Our Ref: RD/209087/00055

**Application by Chrysaor Production (UK) Limited ("the Applicant") for the Viking CCS Pipeline
Planning Inspectorate Reference: EN070008
Air Products (BR) Limited (Interested Party Reference Number: 20047092)
Written Representation**

Drawn	Checked	Approved	Date
AH	SM	RB	15/03/24
GH Project Number	Scale	Page Size	
125724.00008	1:2,500	A1	
Harbour Energy Drawing Number	Revision		
GHA-UKOS-P-XX-X-EN-108-00001-01	D3

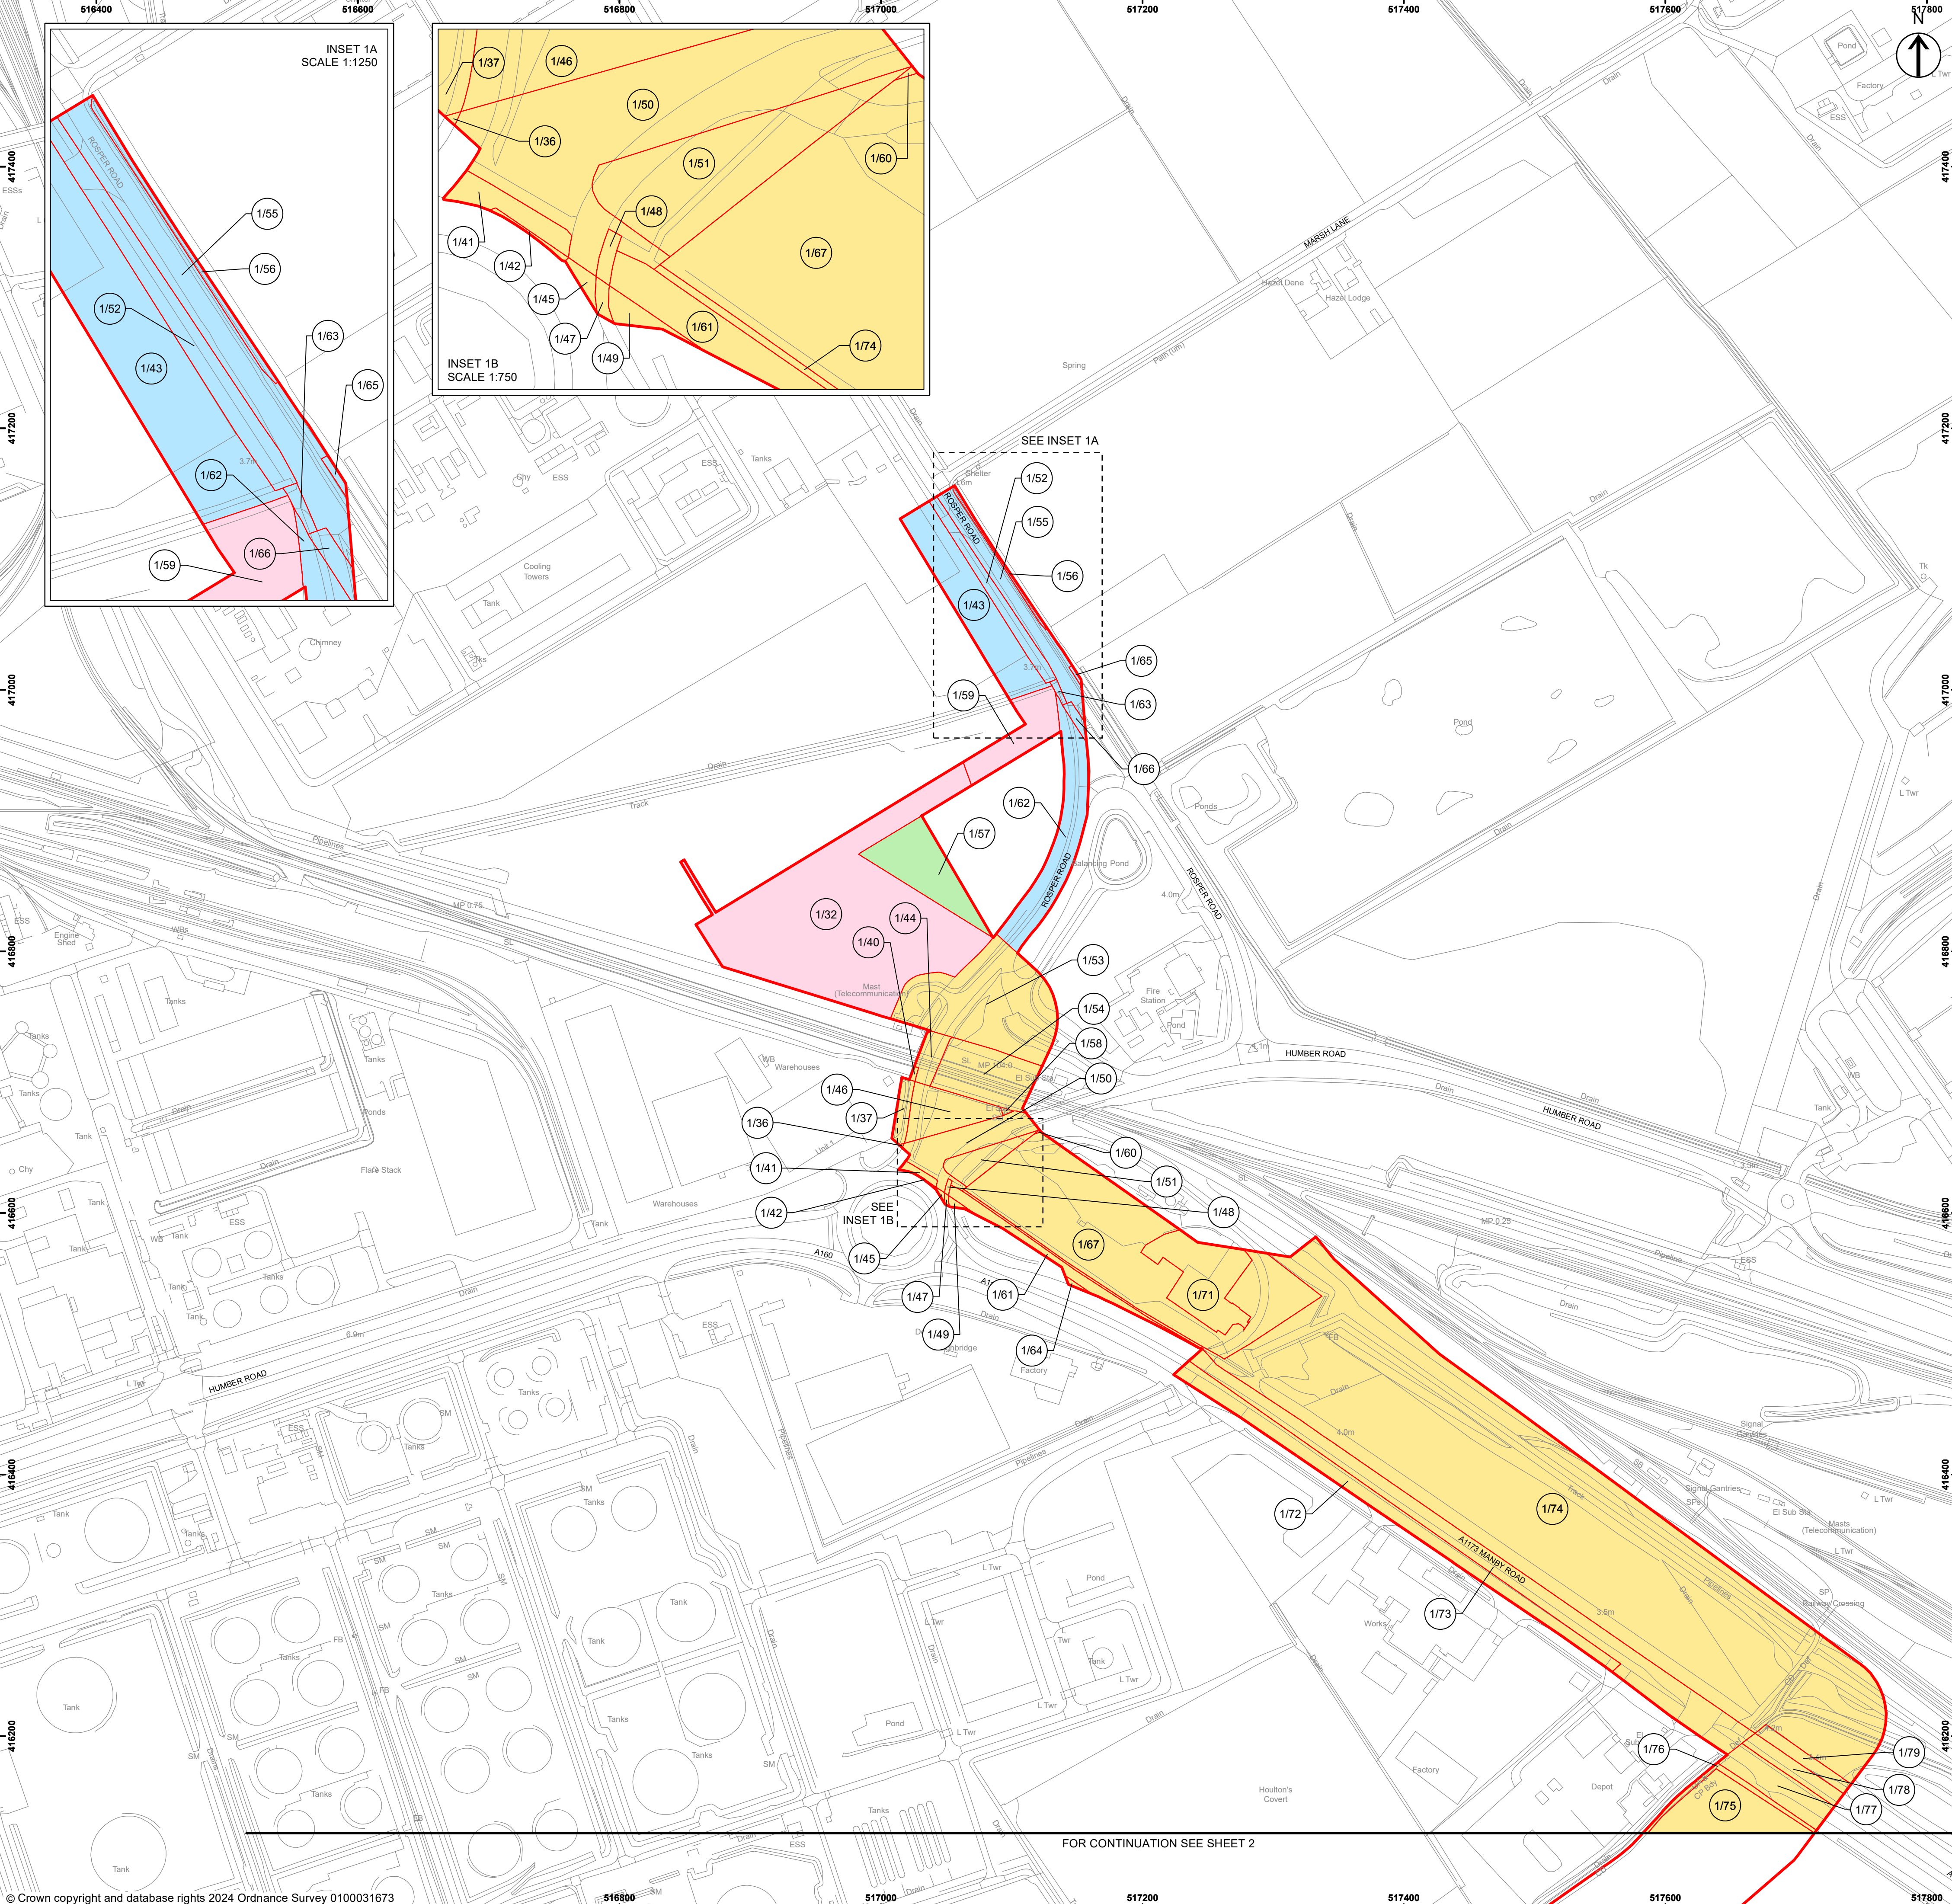
- 3.1 As set out in Air Products' response to ExQ1.5.23 submitted at Deadline 1, there is a discrepancy in relation to Plot 1/57. This plot is shaded green (temporary possession and use) on the Land Plans Revision B [**AS-049**] and is included in Table 5 (Temporary Possession Land) of the Statement of Reasons Revision B [**AS-043**], however, is described in the Book of Reference Revision B [**AS-045**] as "permanent acquisition". Air Products requests that the Applicant clarify the powers sought in respect of Plot 1/57.
